**WEST SUSSEX COUNTY COUNCIL  
INFRASTRUCTURE CONSULTATION**

**SUBJECT: LU/386/10**

**Seanormous, Rope Walk, Littlehampton**

**New dwelling**

BLOCK PLAN

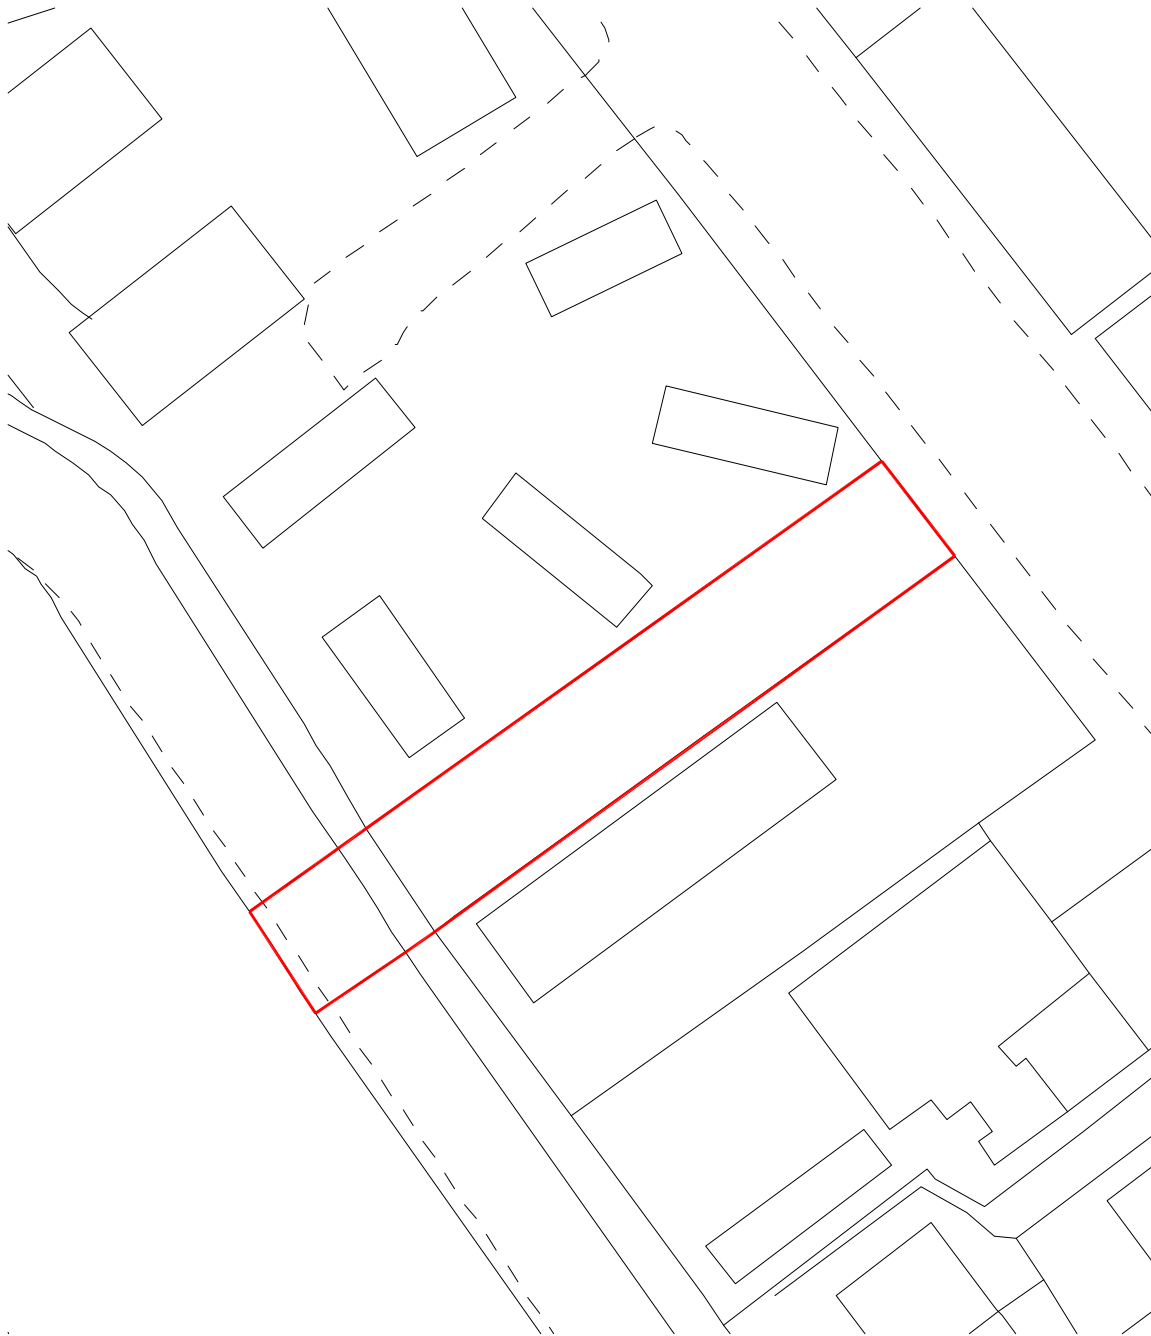
The application proposes two off-street parking spaces to serve the new dwelling, however there is no plan showing their location. WSCC therefore requires **more information** regarding the parking arrangements.
